NON-JURISDICTIONAL WATER IMPOUNDMENT STRUCTURE¹

Name of Dam: Church at Bent Grass Meadows - Pond A Water Division: 2 Water District: 10

DETENTION BASIN STAGE-STORAGE TABLE BUILDER

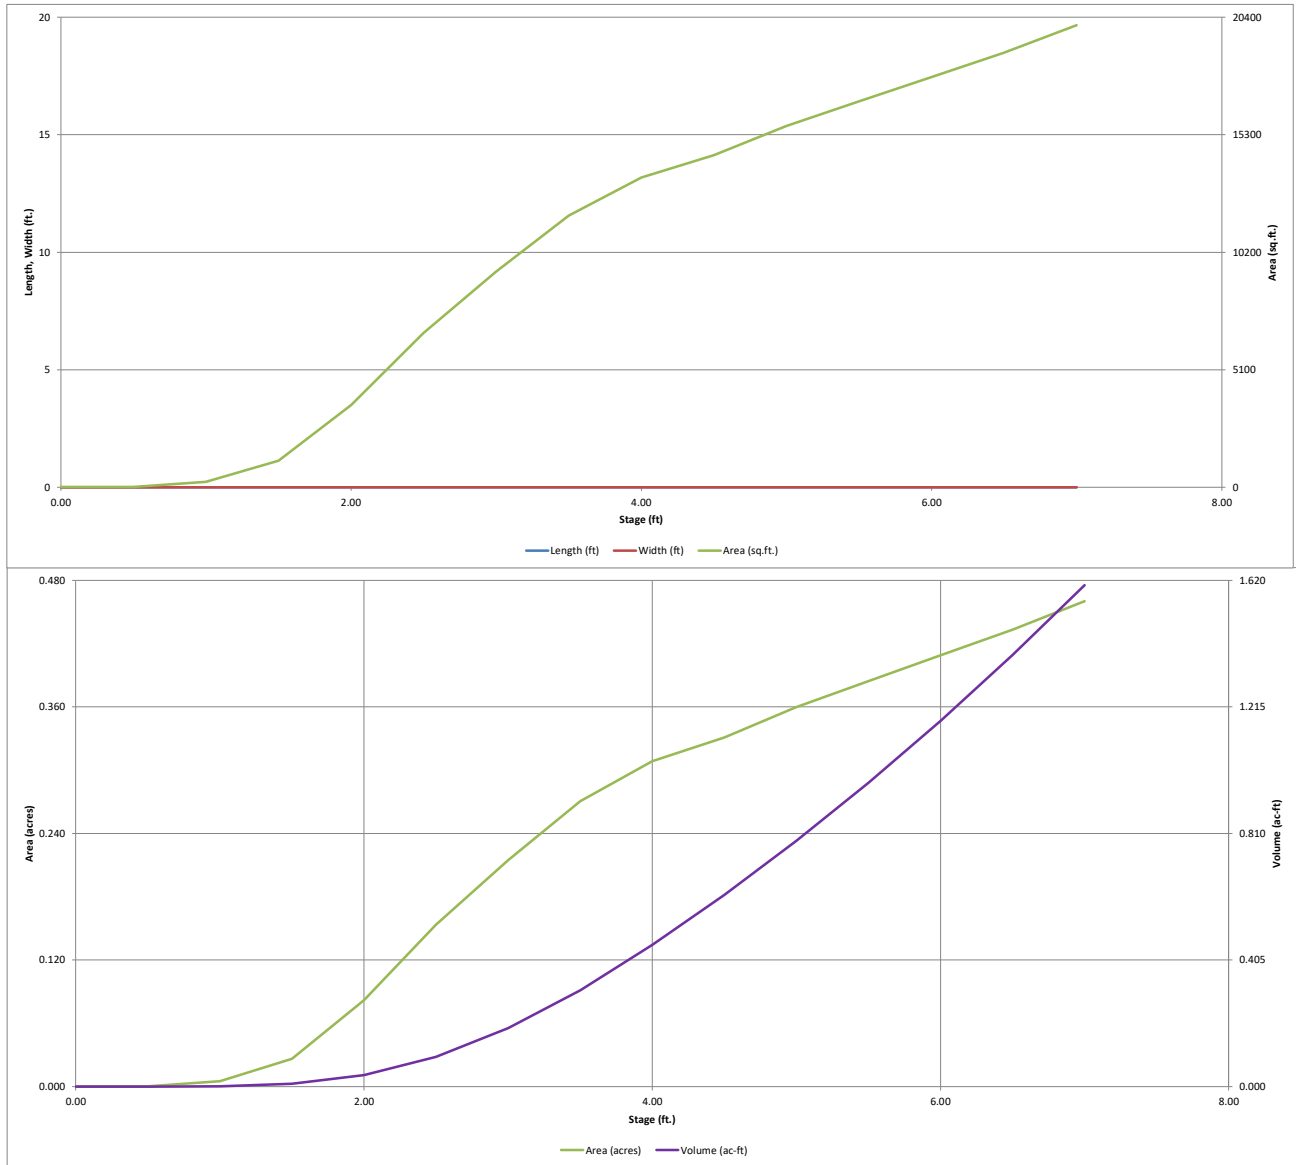
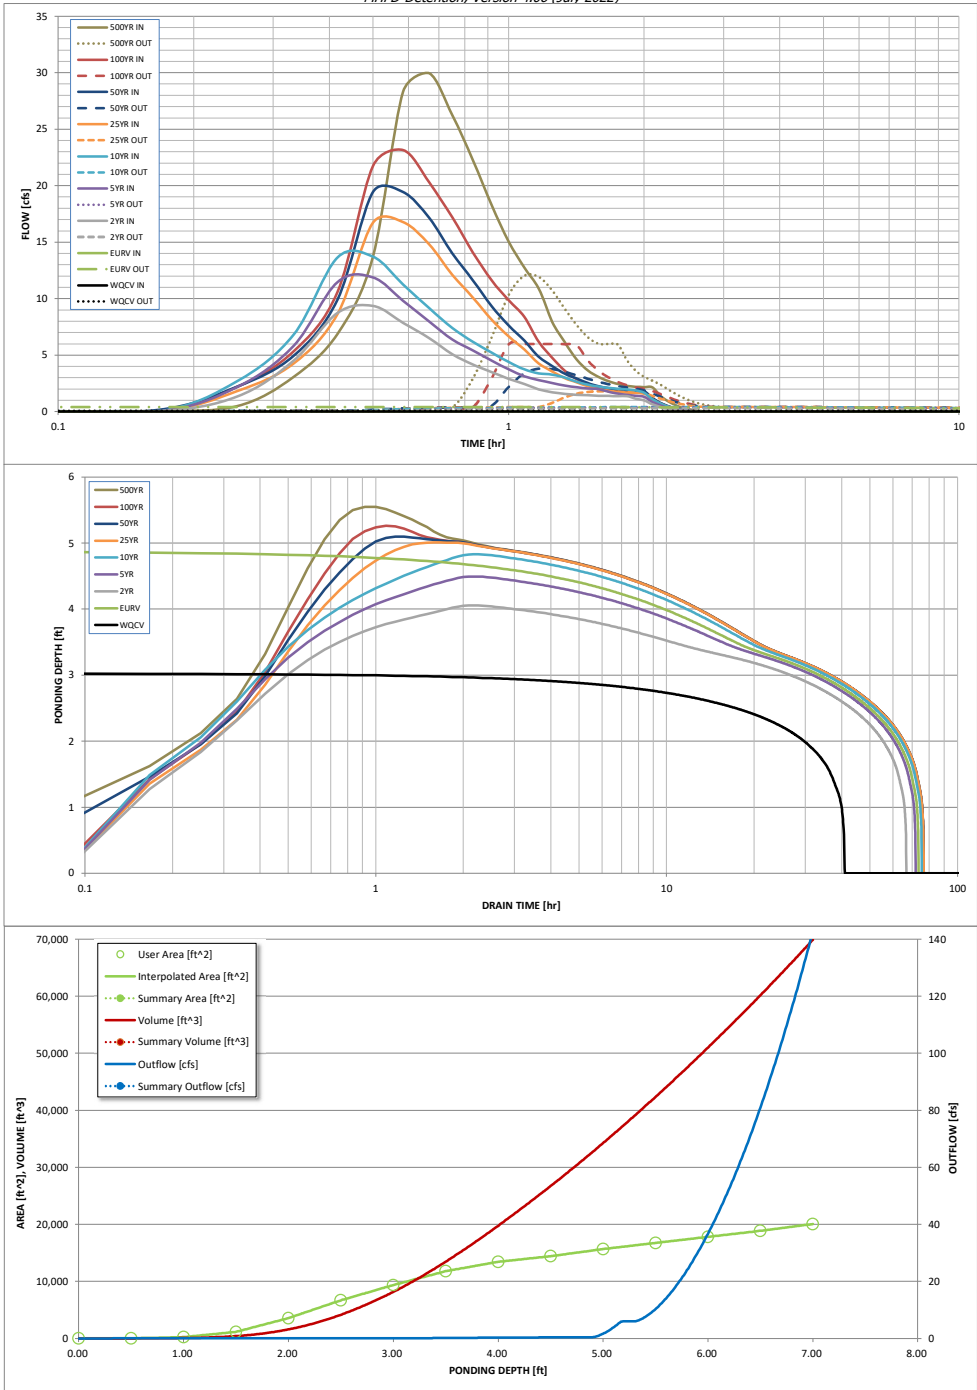
- Bottom Width: 15 ft., Side Slopes: 4 H:1V, Freeboard³: 2.75 ft. ***Does not qualify as a dam, 1.0' freeboard required by County**
